Application by Springwell Energy Farm Limited for a development consent order to install solar PV panels to generate up to 800MW of power and on-site battery storage and associated infrastructure including battery energy storage system, access provision and 400kv underground cable corridor to facilitate the connection to the proposed National Grid substation at Navenby

Comments on submissions received at deadline 1 (for deadline 2) from Lincolnshire County Council (LCC)

Figure 2: Indicative Construction Timelines of all NSIPs and Major Development Schemes Considered for Potential Interrelationships

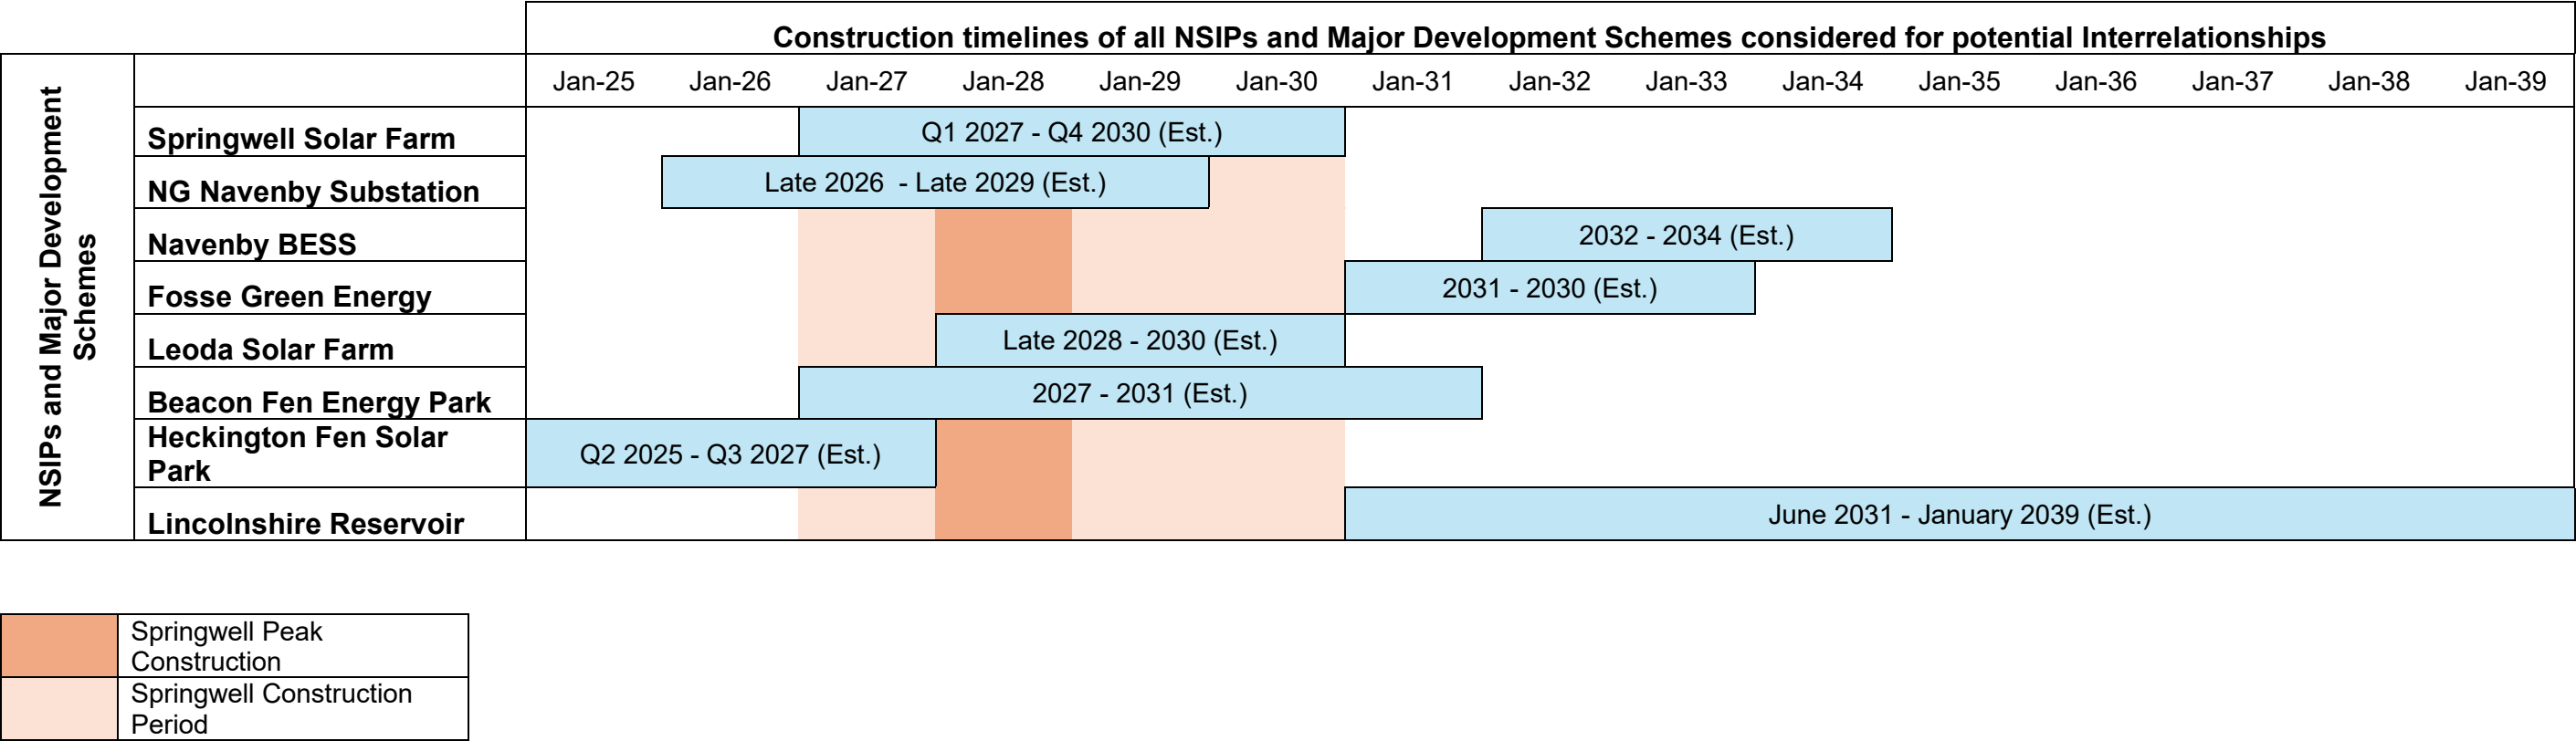
LCC further disagrees with the Applicant's assertion that interrelationships between Springwell and other projects "are not anticipated", especially when five other schemes are under construction during the same period, with three of those overlapping Springwell's peak construction phase (as shown in figure 2 of the submitted document).
